Subject: Urology Network of New Mexico Private Fire Line Project No. 7556.81  
601 Broadway Blvd. N.E. ( South of Lomas & adjacent McDonald's)

Hello Nilo E. Salgado Fernandez

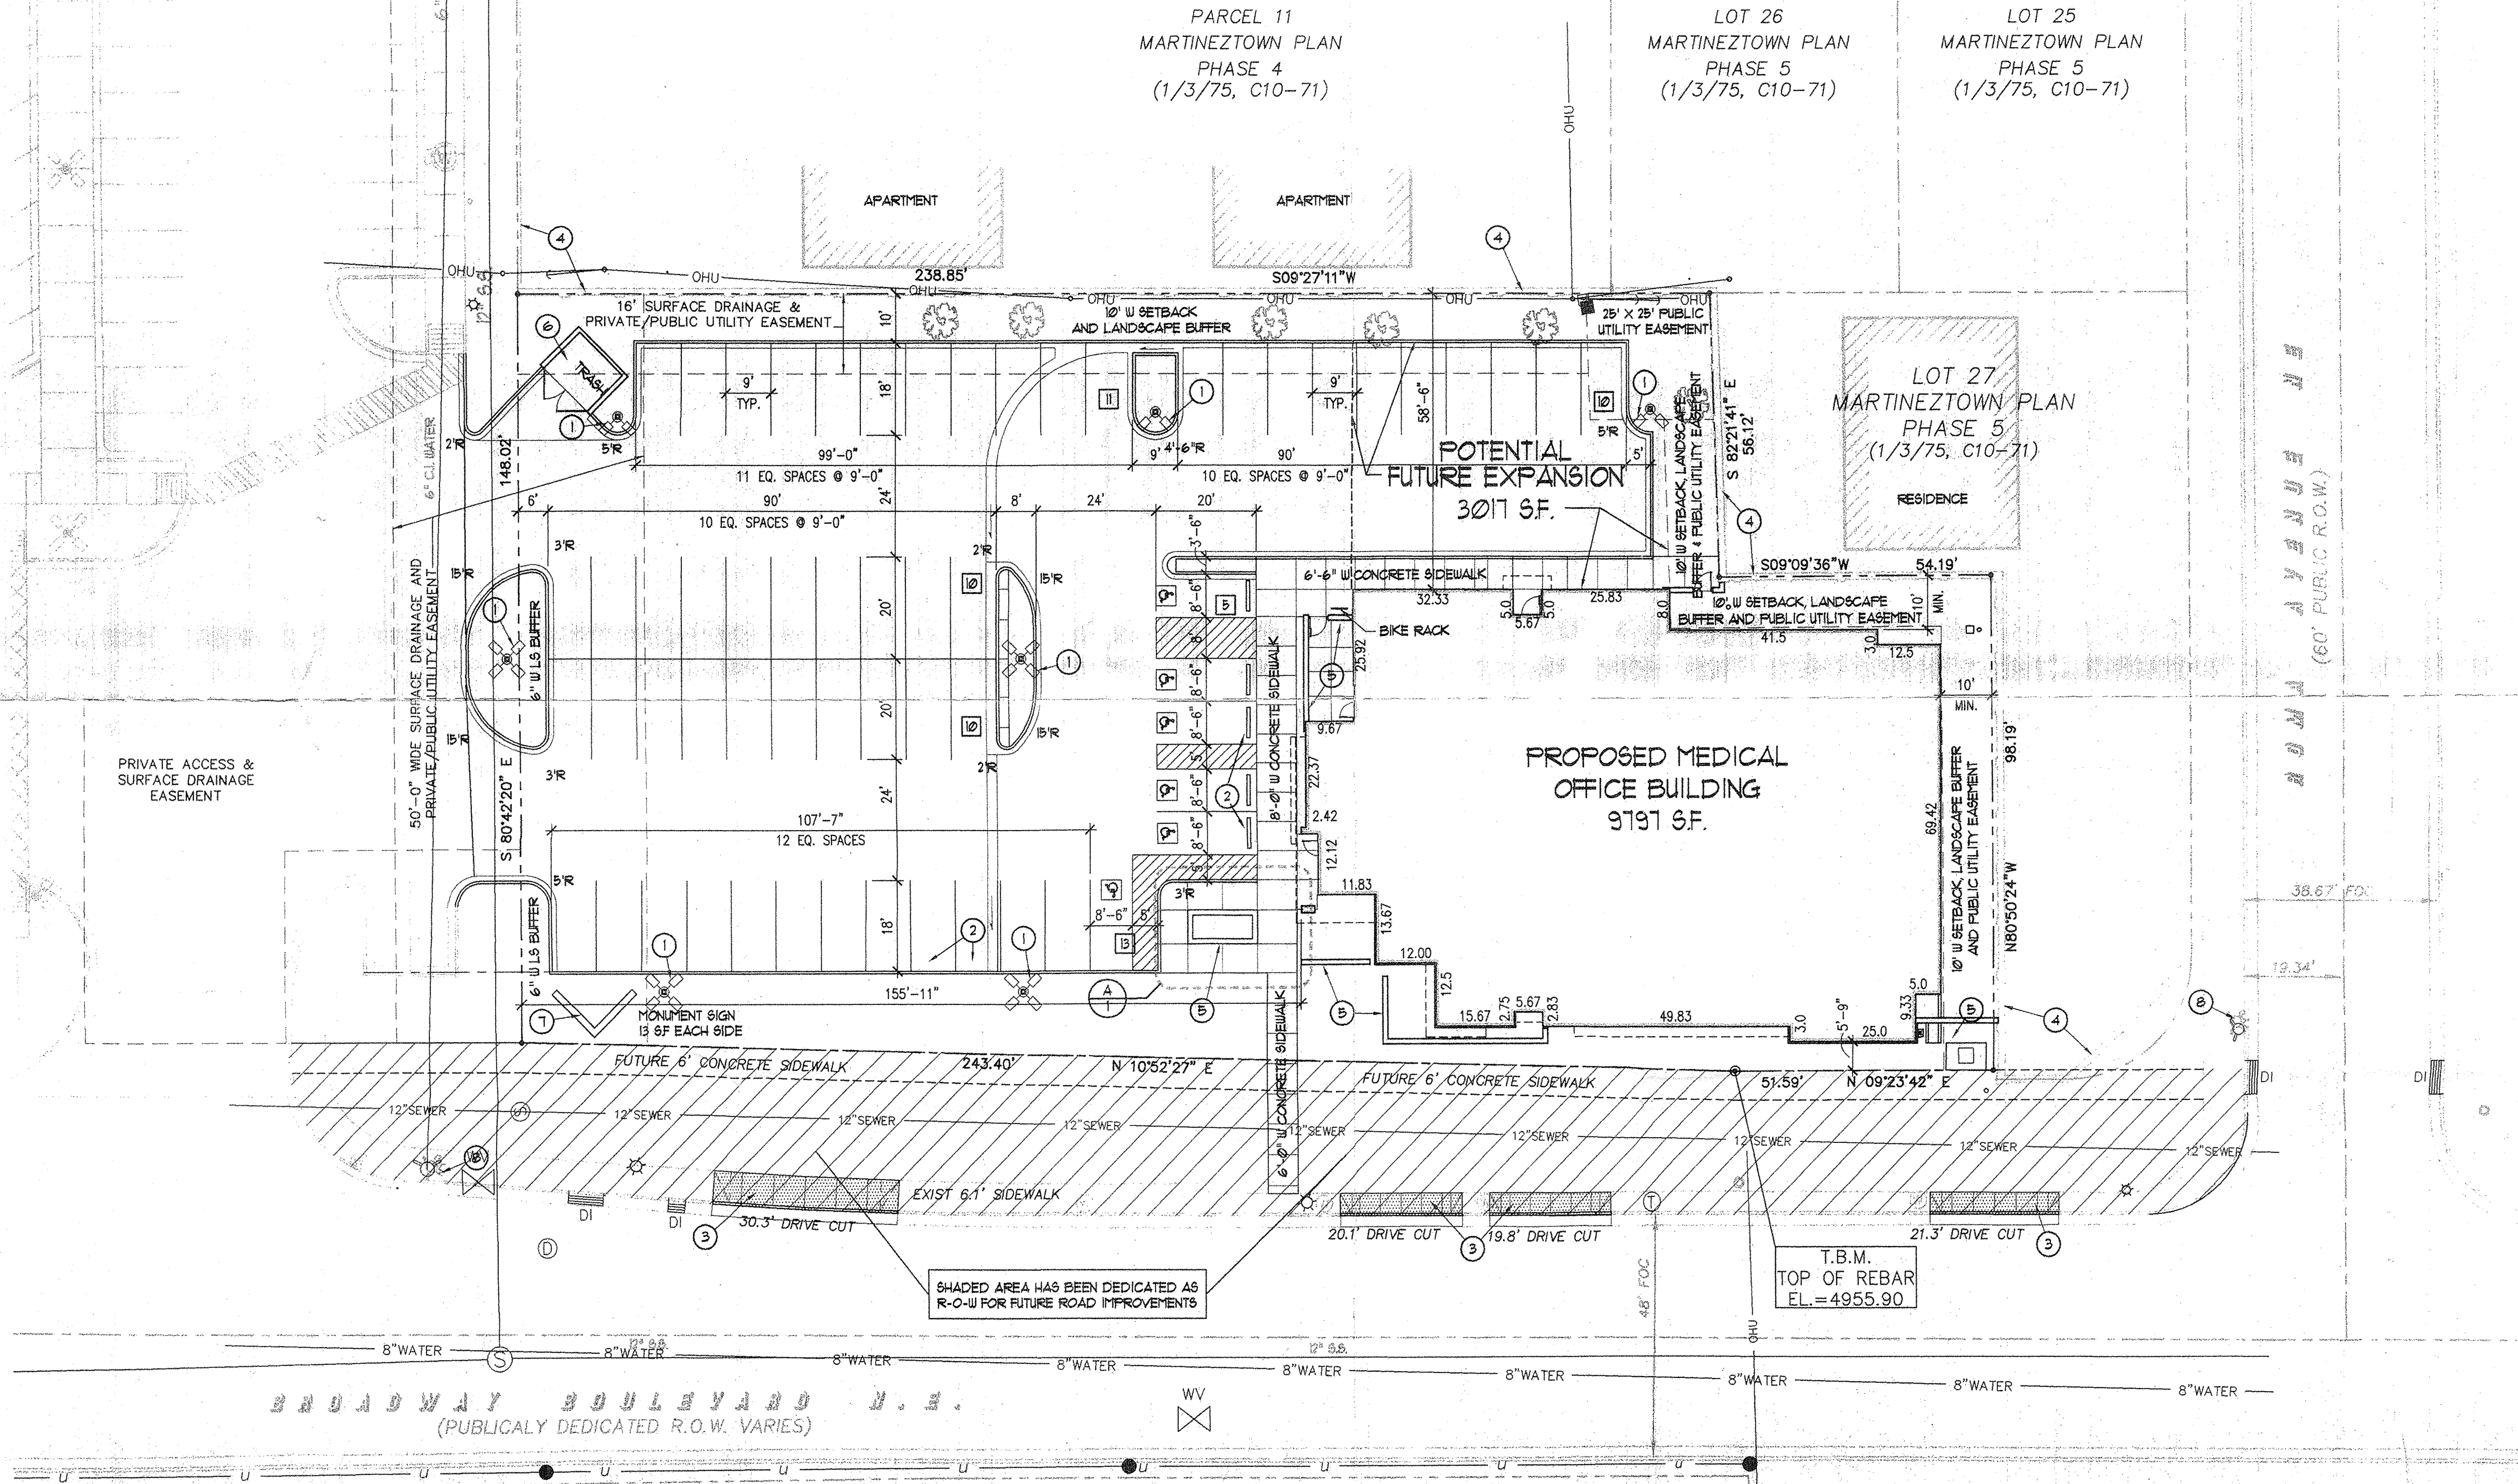
Question, did a field check on the fire line for the aforementioned project on this date, my attention was called to the number of existing drivepads that existed prior to the construction, are they to being removed and replaced with sidewalk? Also the condition of the existing sidewalk in areas has cracked and may create an unsafe condition for pedestrians, not to mention the sidewalk varies substantially in width thru the project area.

*drivepads need to be  
closed (Reflect on  
plans)*
